Application Ref:	2026/0145			 Ribble Valley Borough Council www.ribblevalley.gov.uk
Date Inspected:	14/05/2026	Site Notice:	14/05/2026	
Officer:	EP			
DELEGATED ITEM FILE REPORT:				APPROVAL

Development Description:	Proposed two new conservation roof lights and air source heat pump.
Site Address/Location:	Park View Barn Gisburn Road Bolton by Bowland BB7 4NP

Drawing Title
Proposed Part Plan and Elevations

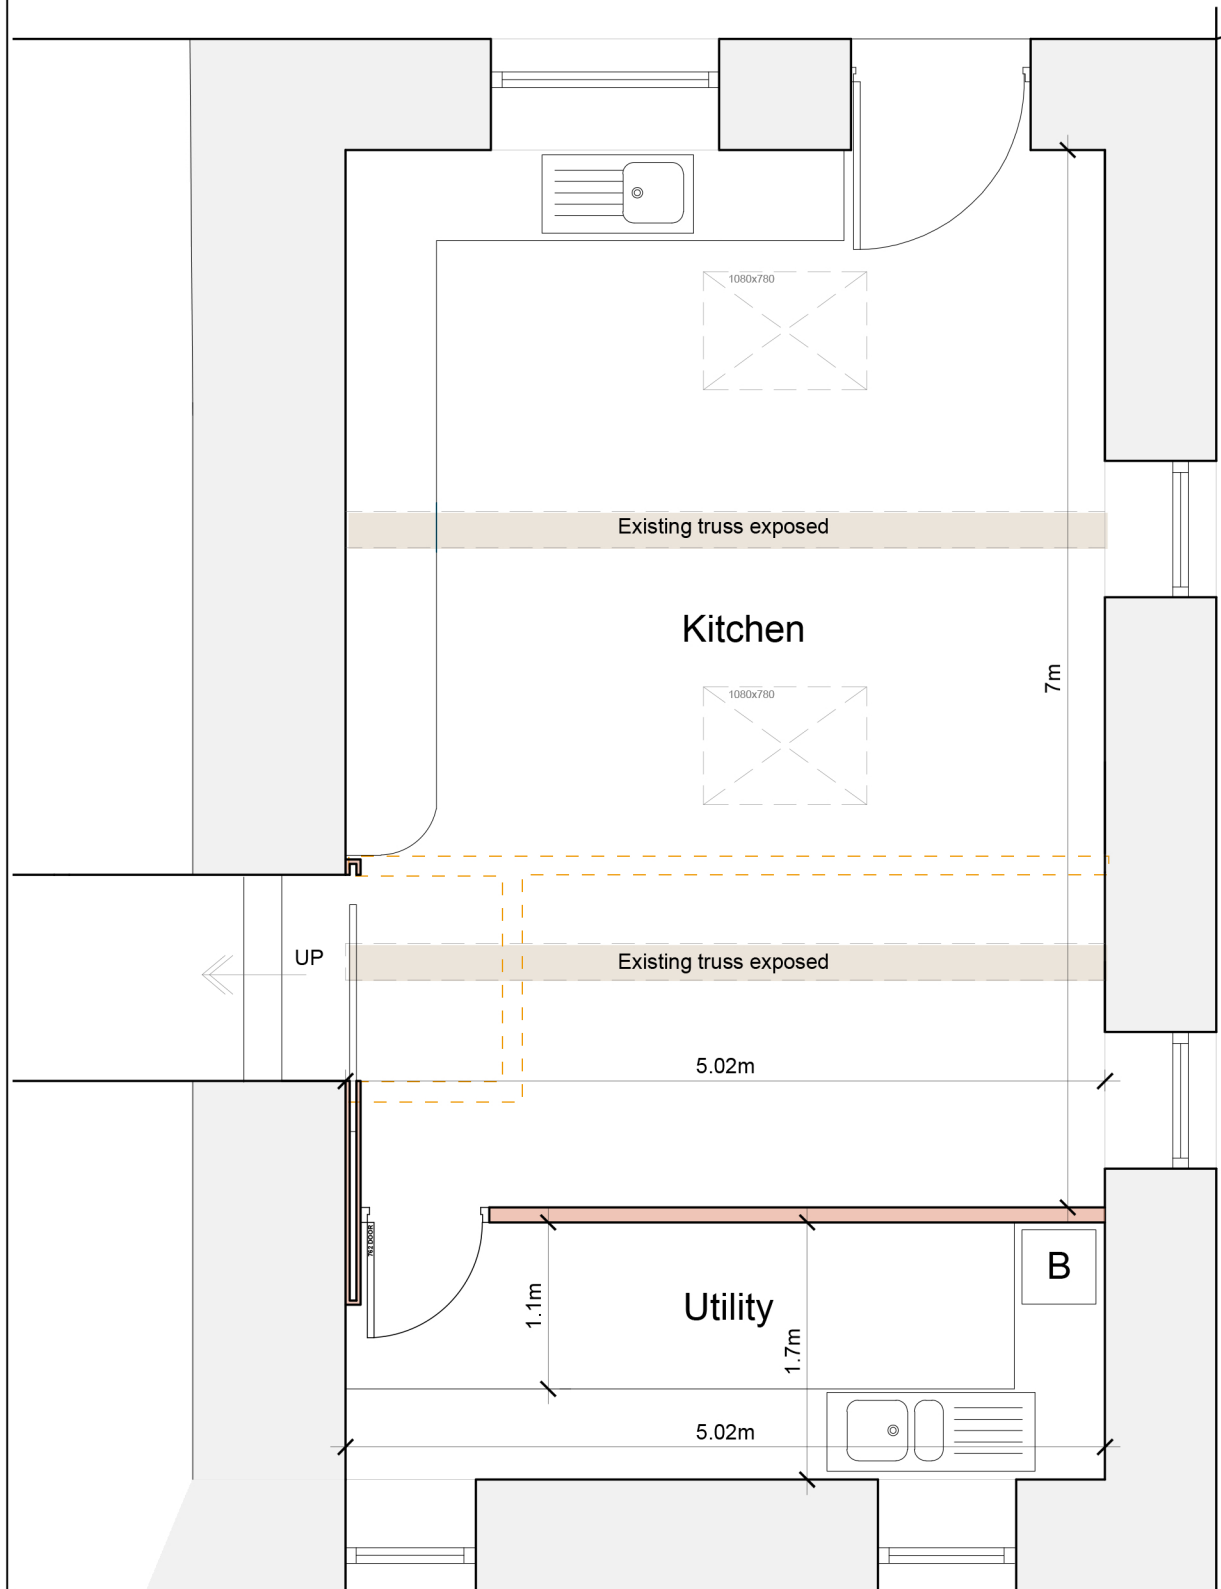
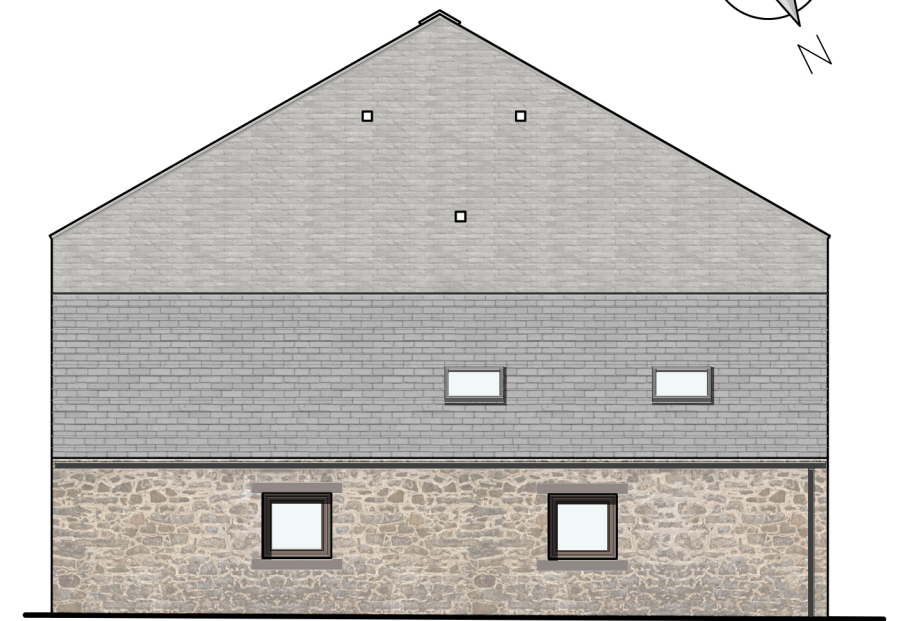
In respect of alterations to the dwelling itself, it is proposed that two conservation style rooflights will be incorporated into the single-storey lean to outrigger. Given the roof lights will be conservation style, they will sit flush with the existing roof and will host an inconspicuous position within the property. Furthermore, the proposed rooflights are small in size, and therefore will not host a significantly visually prominent position.

Drawing Title  
 Proposed Site Plan

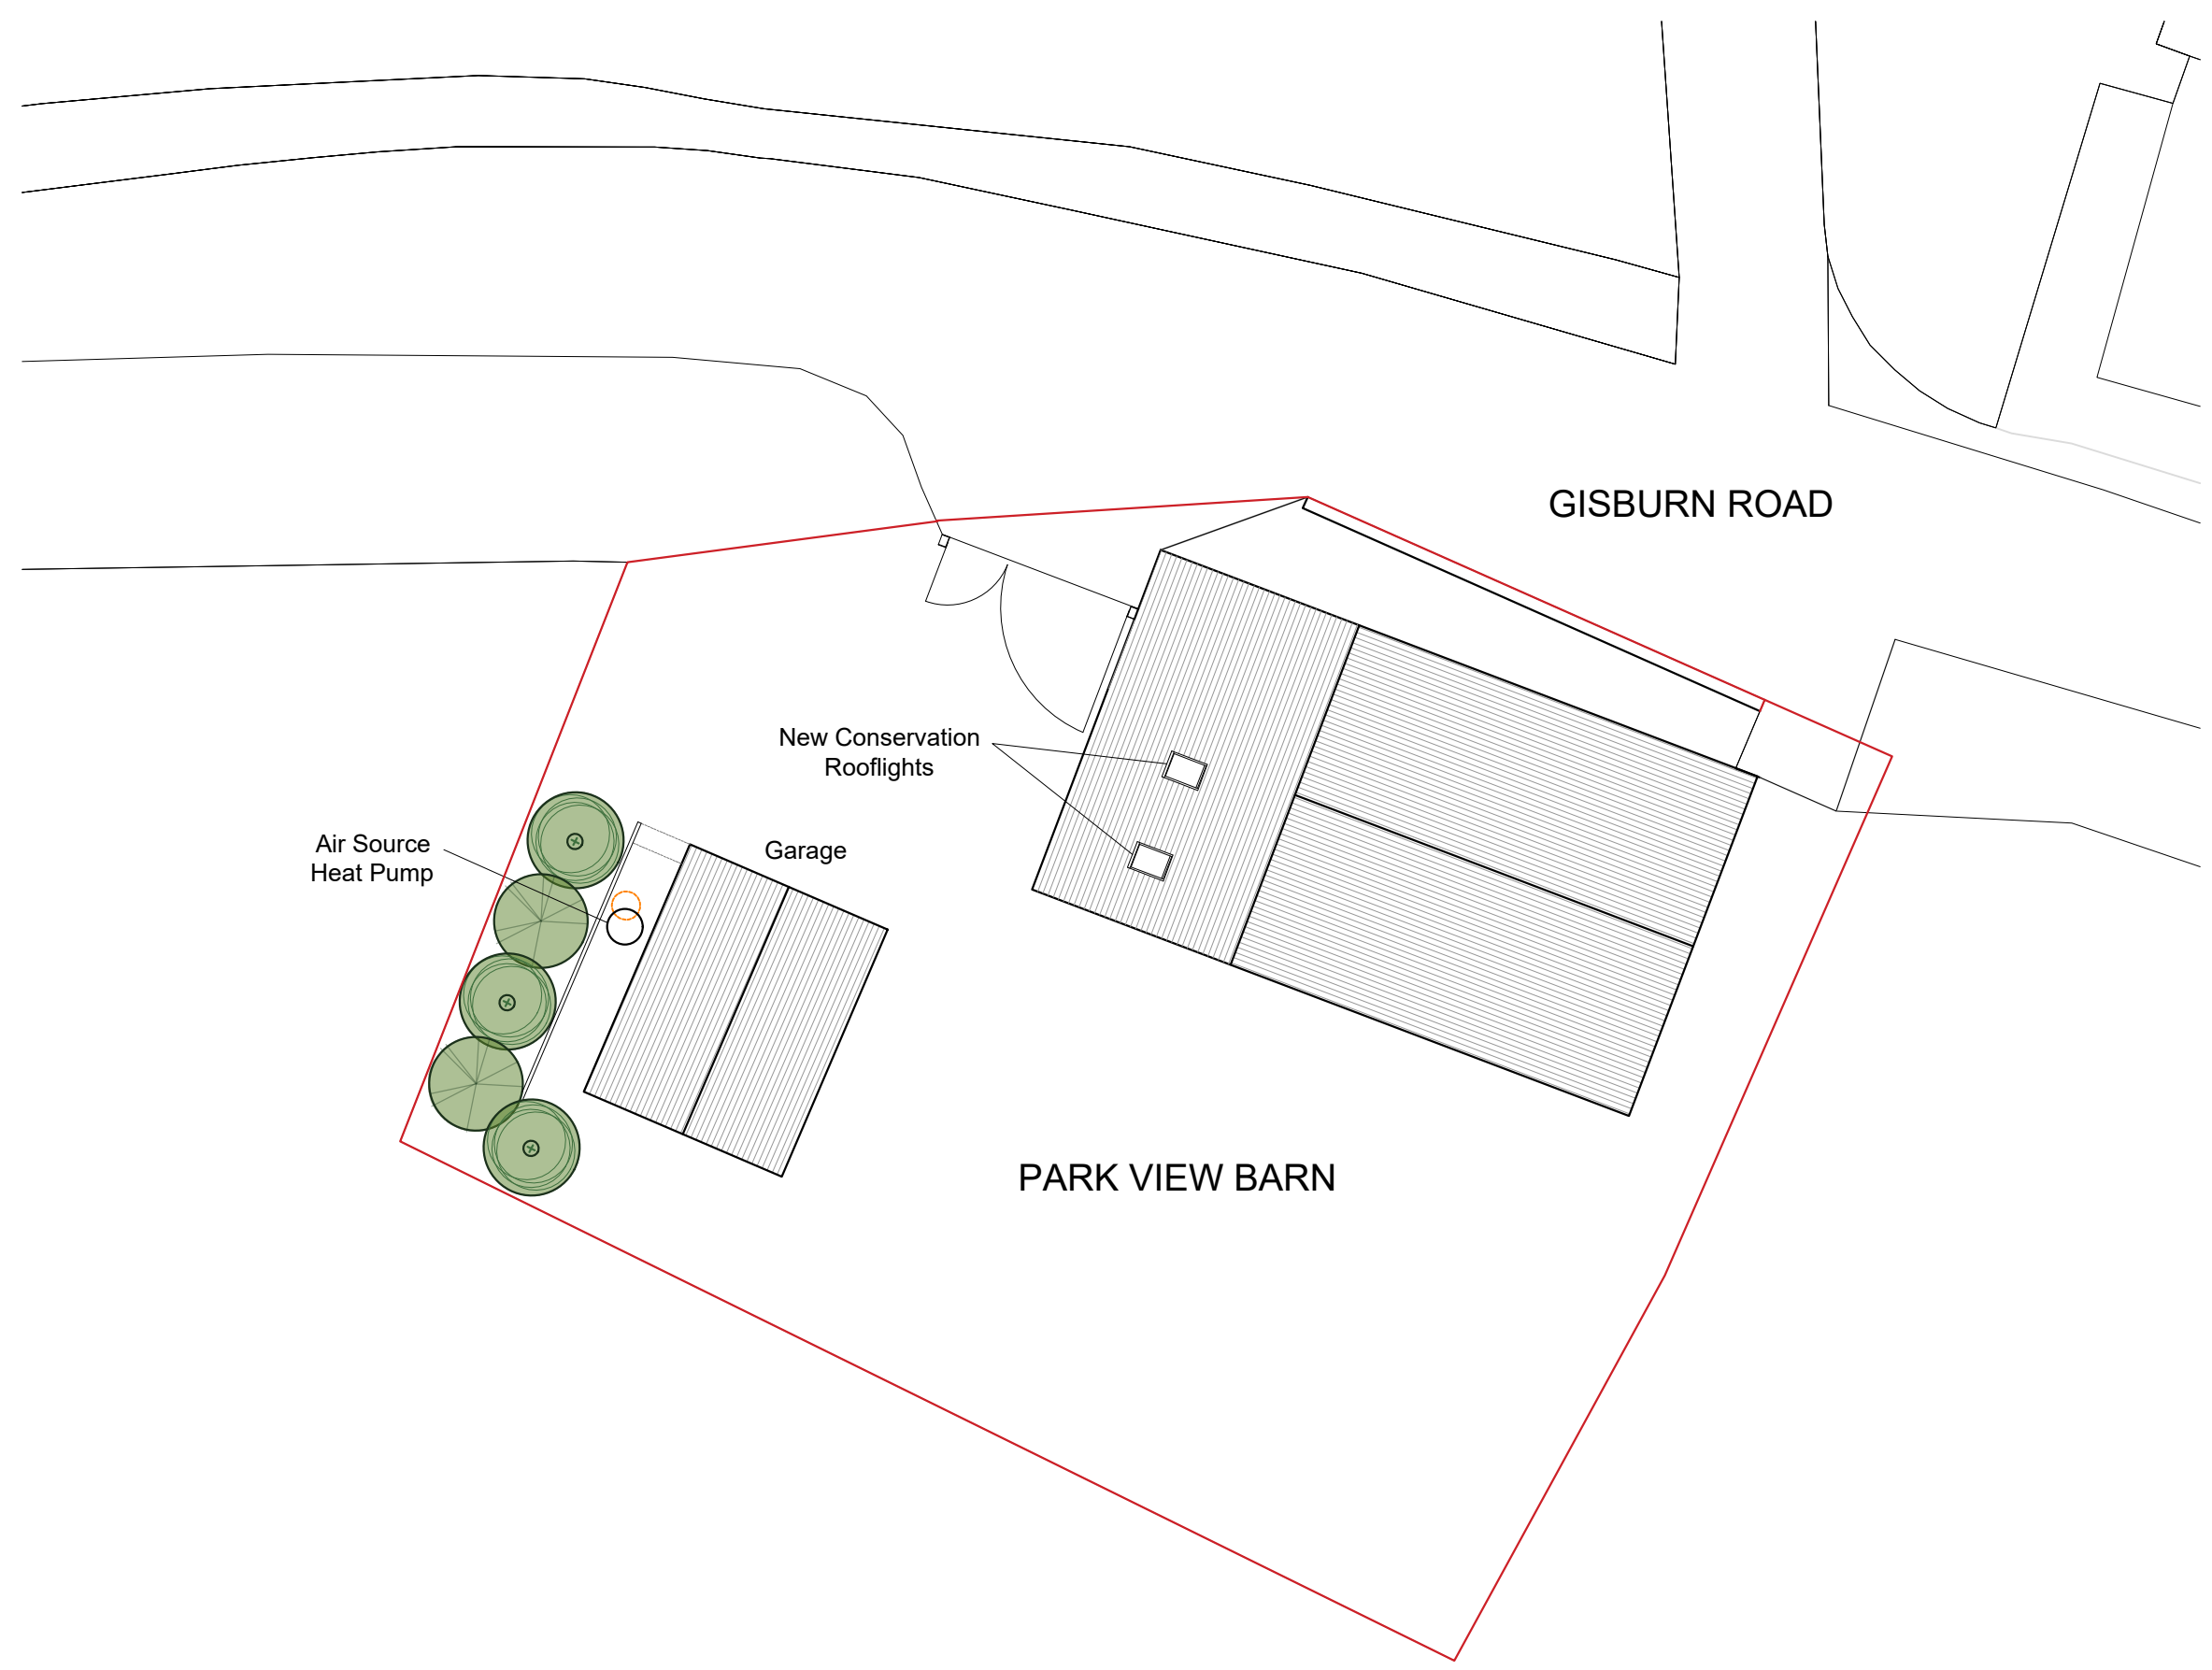
The proposed air source heat pump is to be located adjacent to the detached garage, where there is sufficient boundary treatment to provide screening of this part of the proposal. As such, the ASHP will not be readily visible from within the public realm.

In this instance, the proposed development seeks to introduce an air source heat pump to the site which would be sited directly adjacent to the existing detached garage. Technical data for the air source heat pump has been provided in support of the application and reviewed by the Council's Environmental Health officer who has raised no issues with respect to noise impacts upon the site's neighbouring receptors from the air source heat pump. In addition, the proposed air source heat pump would be sited well away from the site's surrounding residential receptor.
